POST EPC MEMORANDUM

RE: PR-2022-007103_SI 2023-00693 –Site Plan-EPC_3200 Broadway Blvd. SE Travel Stop

The agent (Tierra West) for the Loves Travel Stop Located at 3200 Broadway Blvd. SE, has worked with Staff to fulfill post EPC requirements to meet Conditions of Approval, 1-10. See EPC Notice of Decision (NOD) dated 6-15-2023.

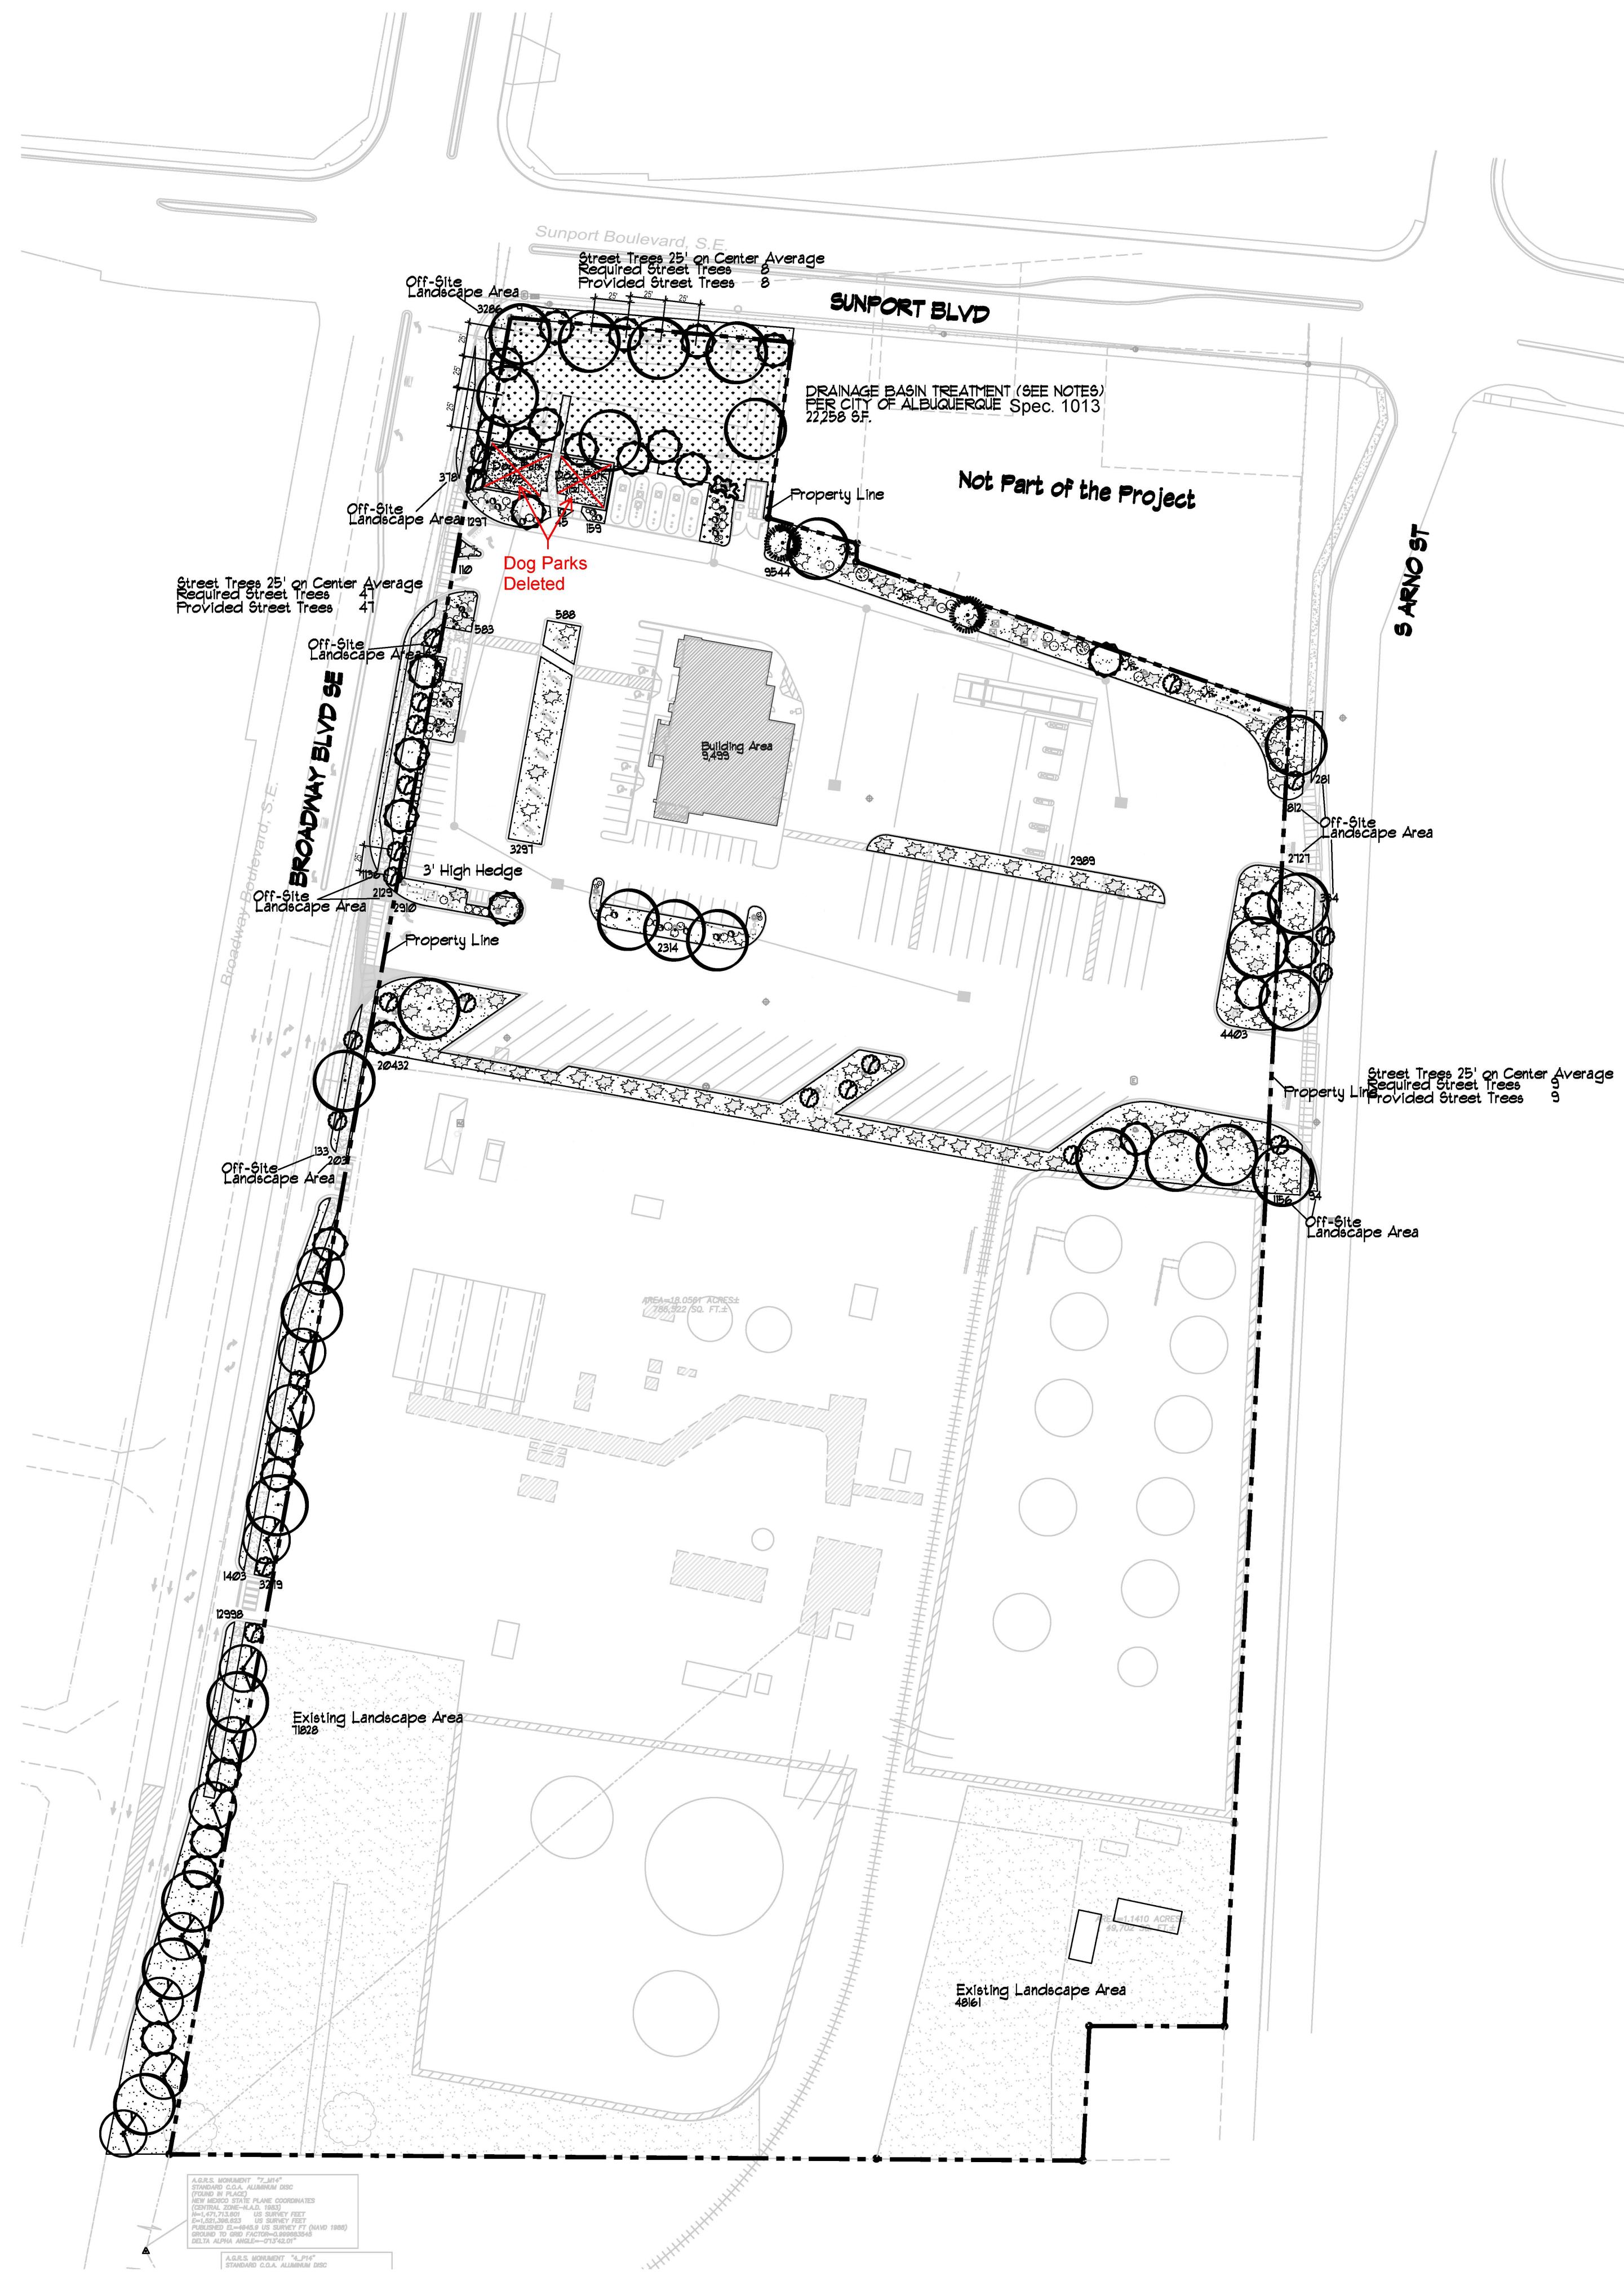
6. Condition 6 C was not clear in the Notice of Decision and the applicant changed the title to the plan to Loves Travel Center landscape Plan. This is sufficient.
